Application for Planning Permission for Works or Extension to a Dwelling

Development: Side garage extension, (amendments to previous approval R/193/14).
Replacement porch roof coverings with slate
Location: 67 Sea Avenue Rustington BN16 2DP

DRW NO 2 SCALE 1/50 (A3)
PROPOSED SECTION

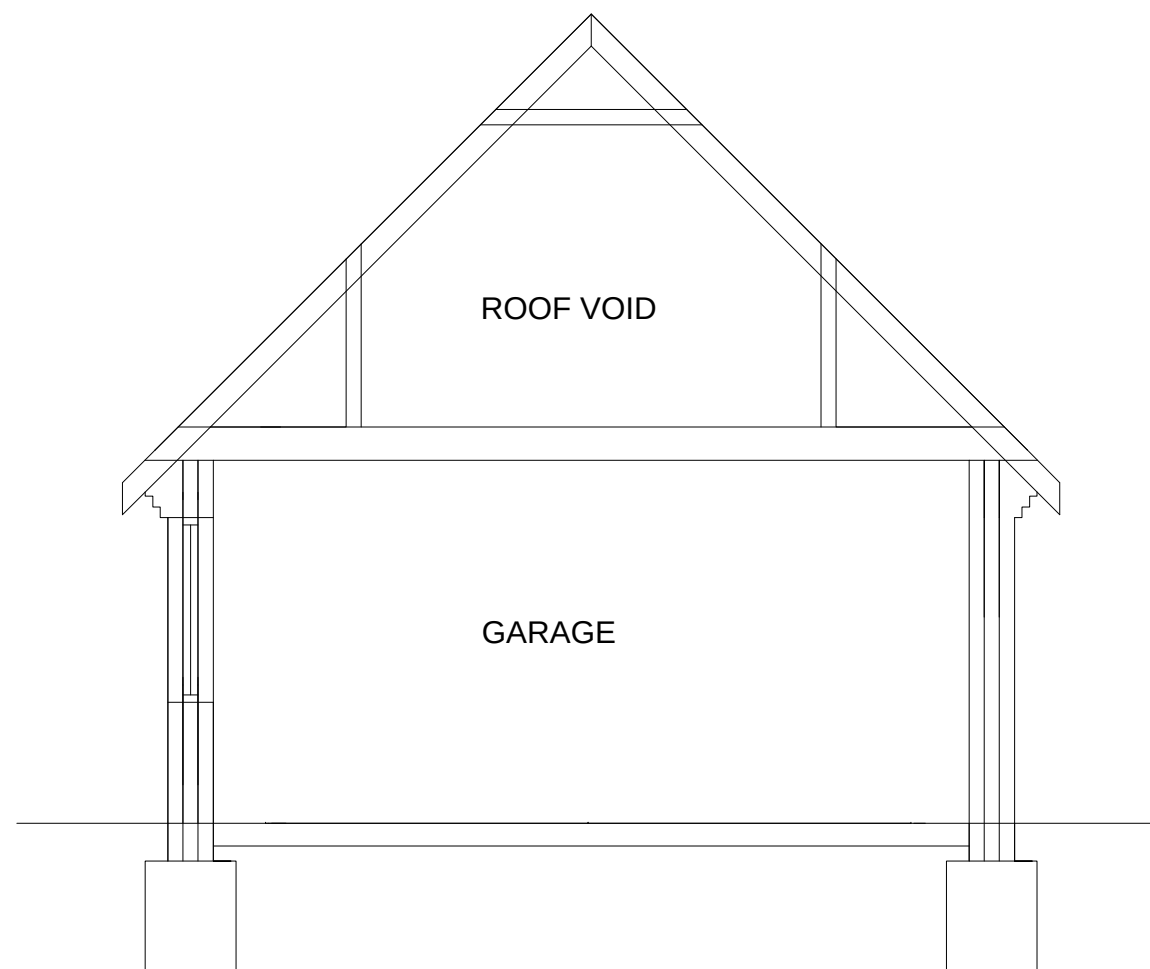
Window: The proposed window at first floor level should be shown on either the section or on a part first floor plan. Please amend.
